Response to Engineering Items Raised in An Bord Pleanála, Fingal County Council and Dublin City Council Pre-Application Consultation Opinion Reports

Proposed Strategic Housing Development at Belcamp, Dublin 17

April 2022

Waterman Moylan Consulting Engineers Limited

Drawing file: Drawings / 19-114-P1120 Proposed Malahide Road Junction Upgrade Layout.pdf

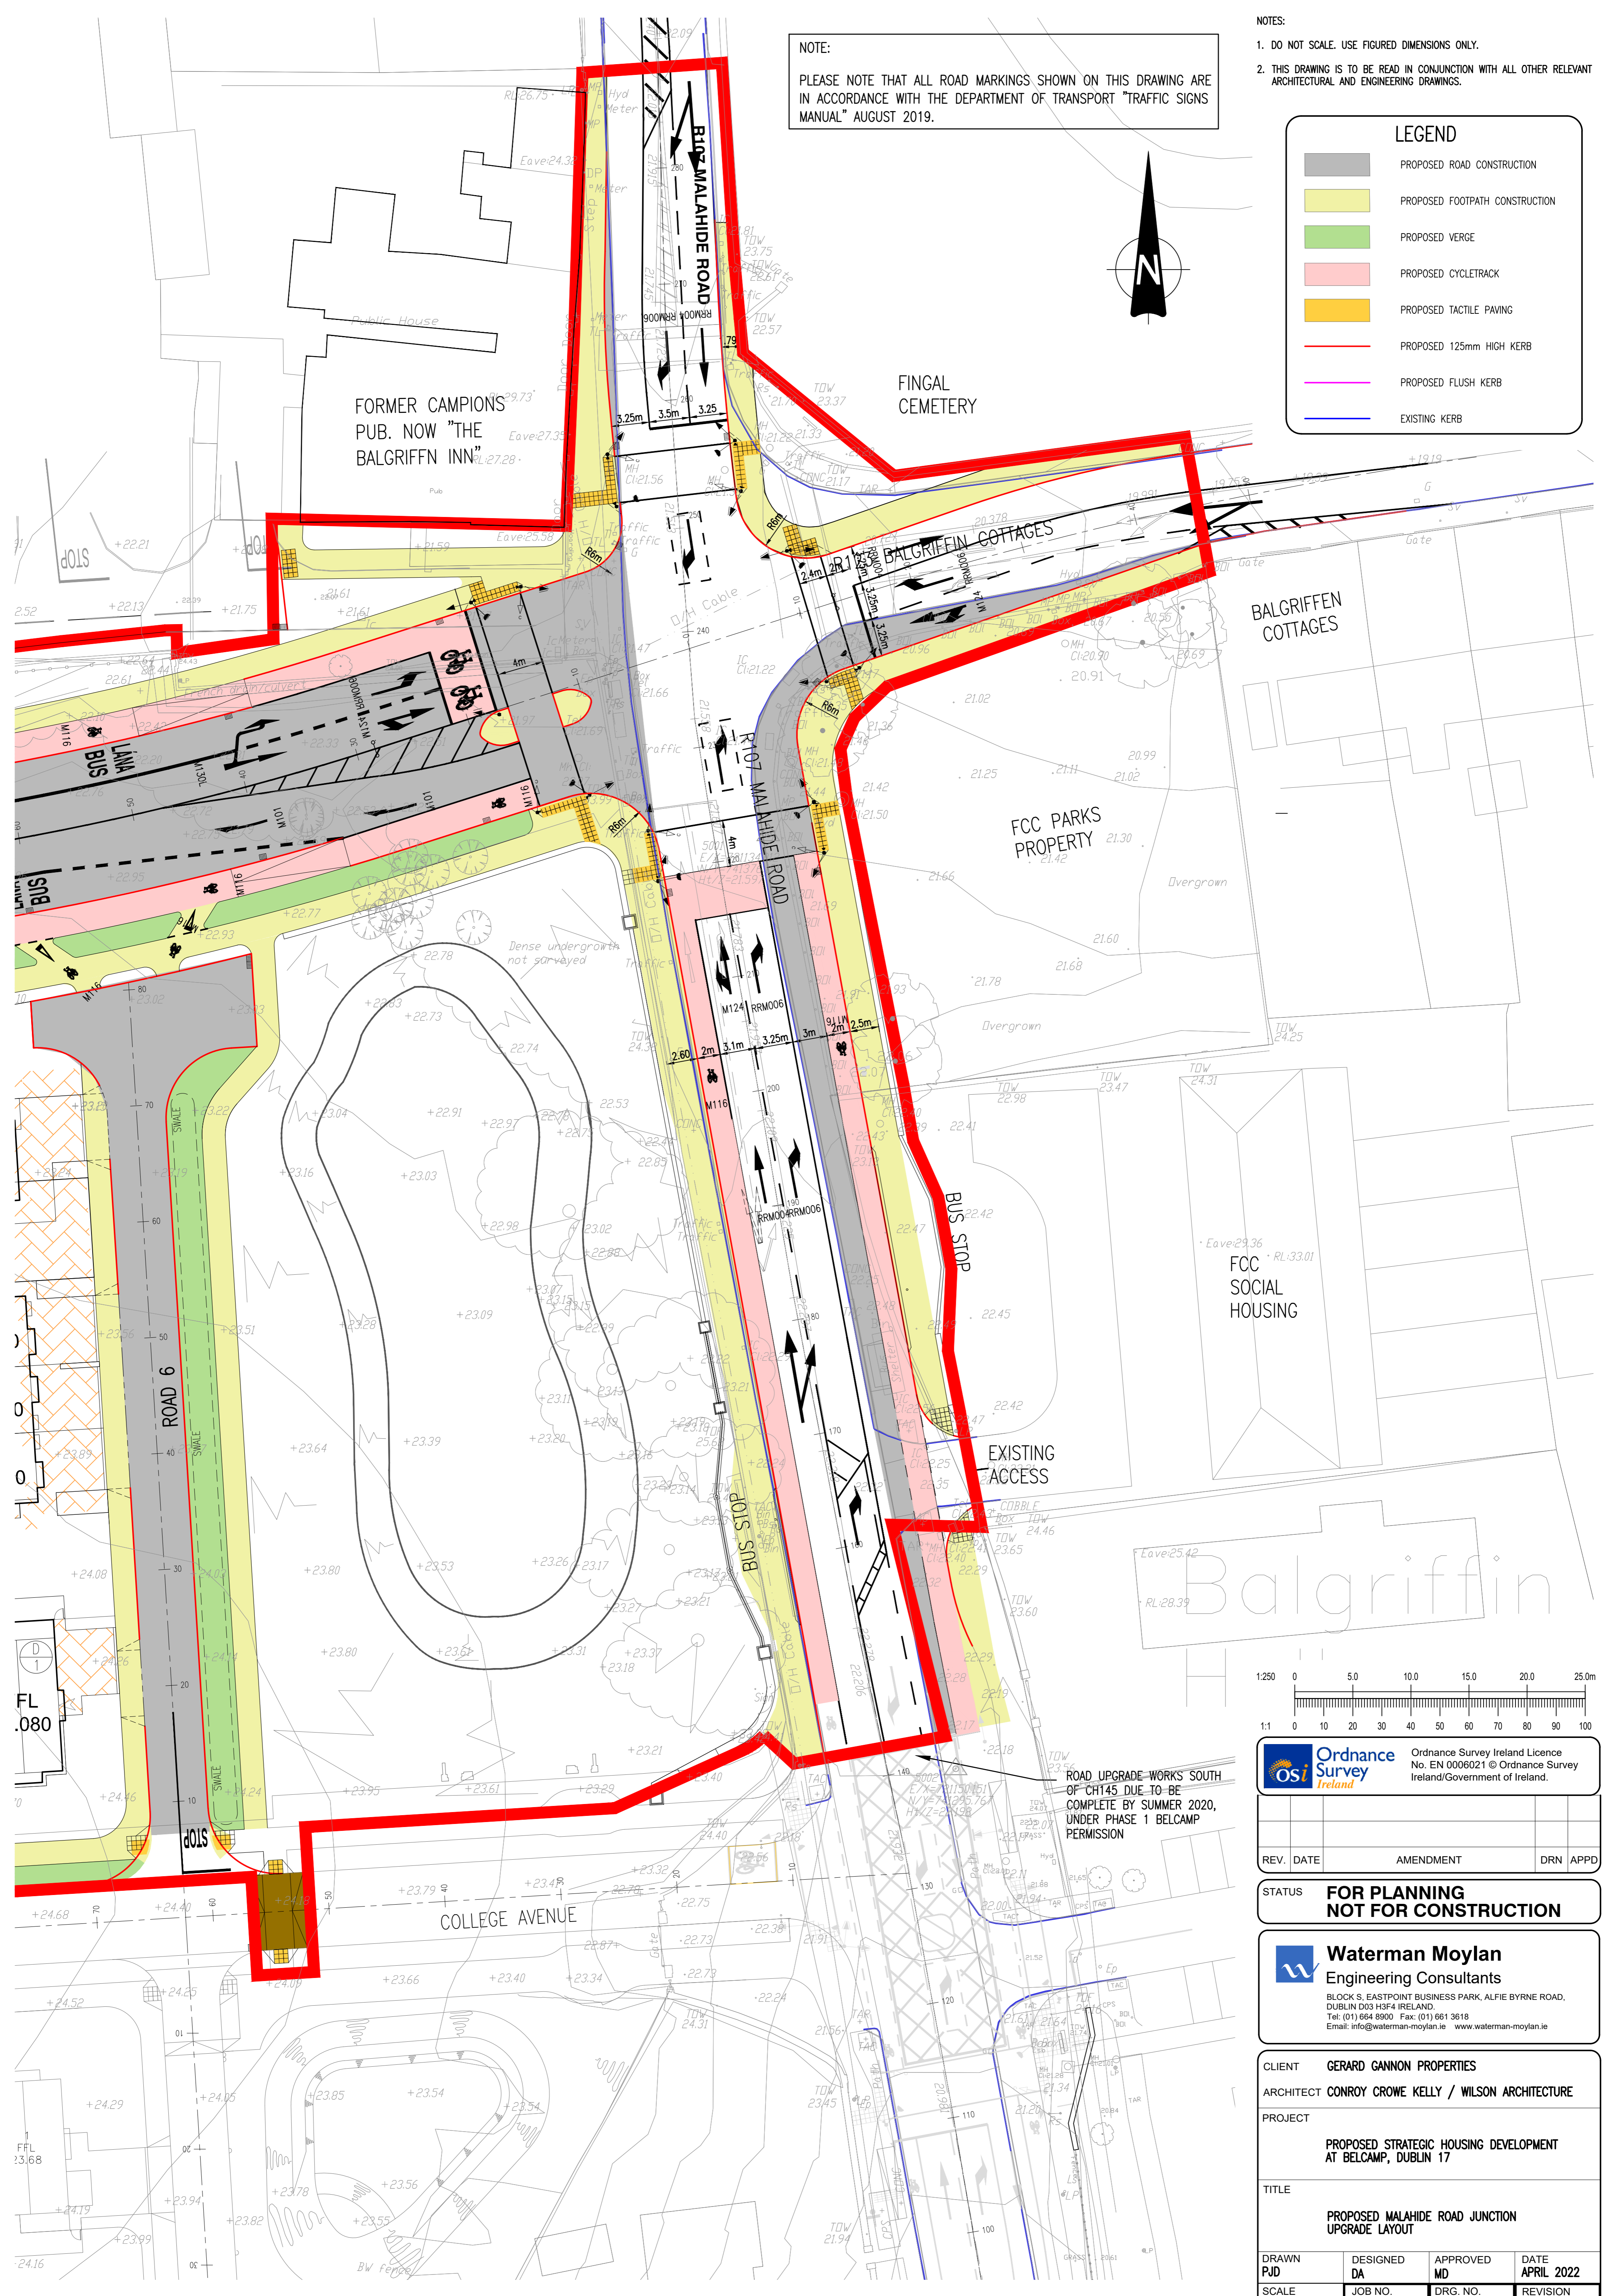
The SFTS recommends that the Malahide Road/Balgriffin Road junction should be upgraded with signals and turning lanes, while also providing a safe and attractive environment for pedestrians

and cyclists. This upgrade has been given a decision to grant permission by Fingal County Council under Phase 1B of the Belcamp development works (F21A-0401), along with approximately 350m of the EWLR. Nonetheless, this subject application also includes the proposed junction upgrade works, along with the approved ~350m of the EWLR, to ensure this application can provide the entirety of the link road from the Malahide Road to the site.

The junction is proposed to be upgraded to form a new 4-way signalised junction, with the EWLR forming the western arm of the new junction. The proposed junction includes new right-turning lanes and cycle facilities. The upgrade works will extend south on the Malahide Road to connect with the upgrades currently being carried out as part of the Phase 1 development.
